Planning and Development

Reference: **21/00517/F**

Application No.: 21/00517/F

Proposal: Creation of a motocross track and soft landscaping scheme and the change of use of agricultural land to hold moto-cross events including set-up, take down and private practice sessions, with associated camping site, for up to 65 days per year and agricultural grazing (retrospective)

Figure 1: Map of On-site Habitat Enhancement Proposals

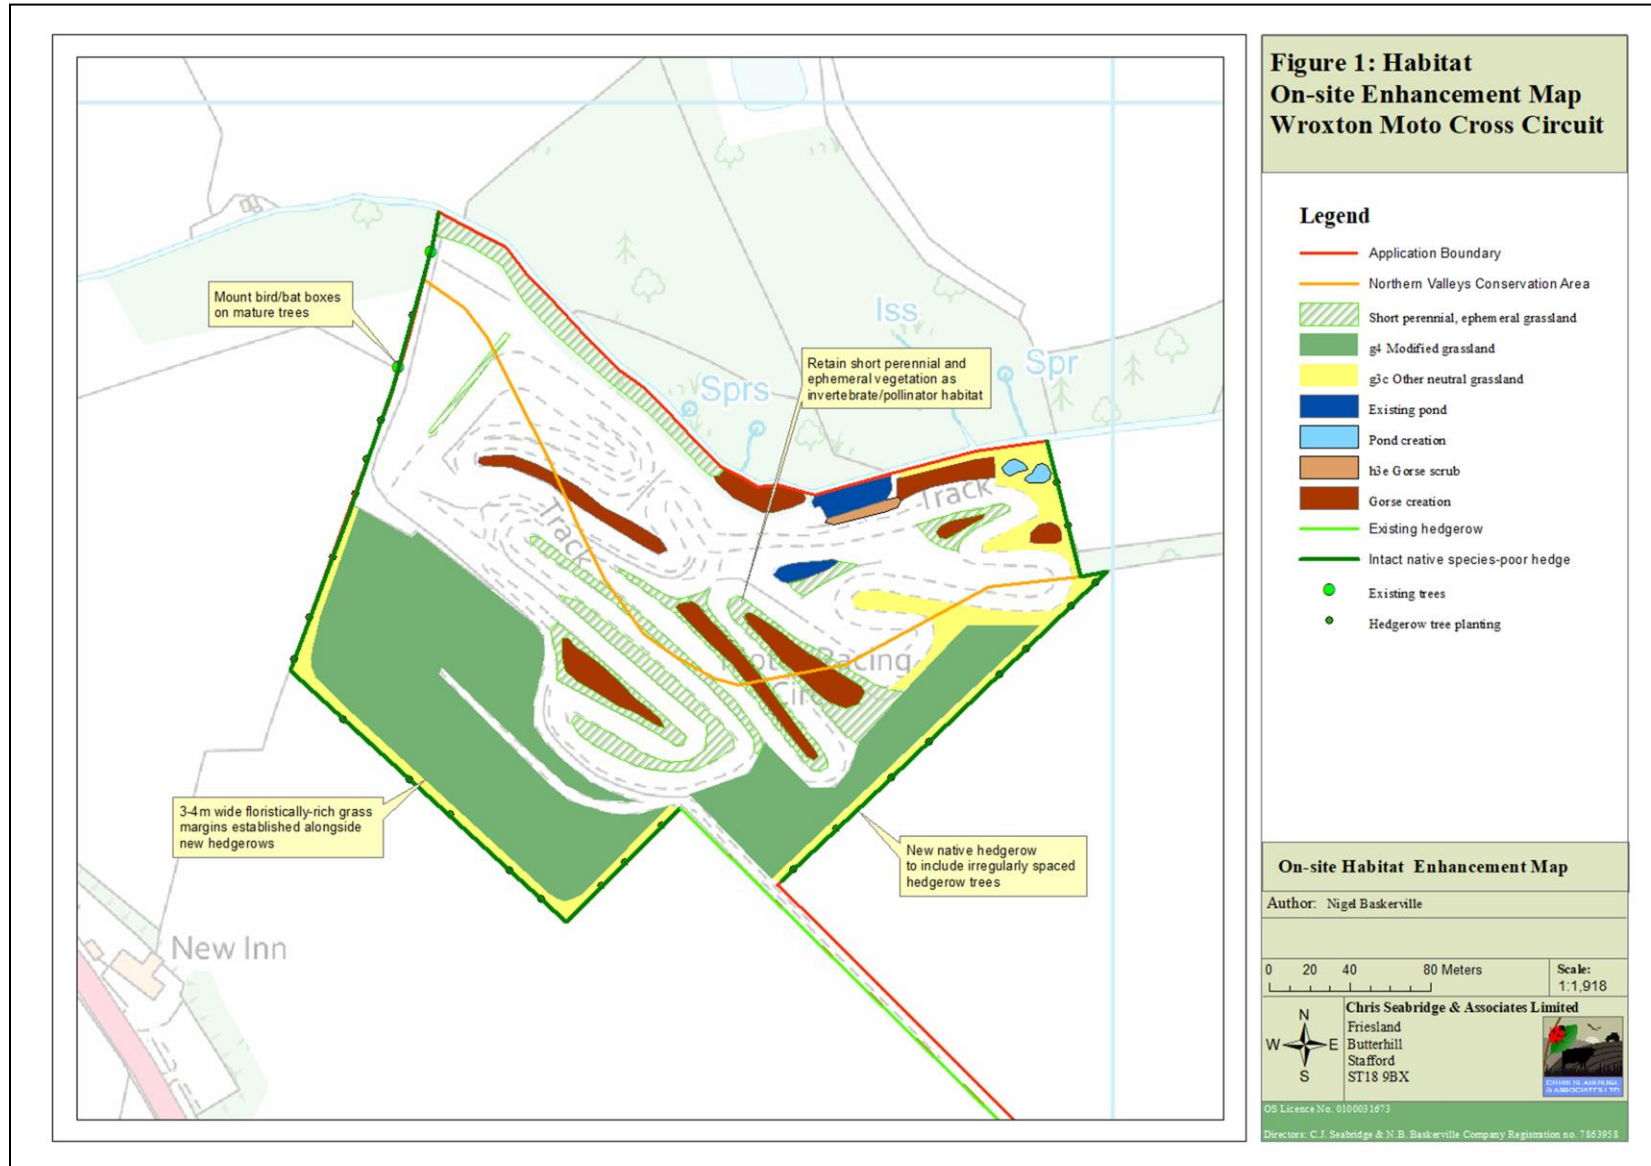
The next point raised by BBOWT, was that ideally there would be less exposed soil overall, and certainly no increase, and in particular not so close to the brook as presently. The applicants have submitted an amended 'Habitat Enhancement Proposals' plan (Figure 1) that shows that further landscaping would be provided along the northern boundary, and that much of the exposed track would be planted.

The proposed conditions would request further detailed landscape and landscape maintenance plans. These details would then come forward as applications to discharge the relevant condition, this process would involve further consultation with you to allow you to make further comments on the details of the landscaping and its suggested maintenance. On the basis of the landscaping plans already submitted, there will certainly at the very least be much less exposed soil then there currently is on the site at the moment.
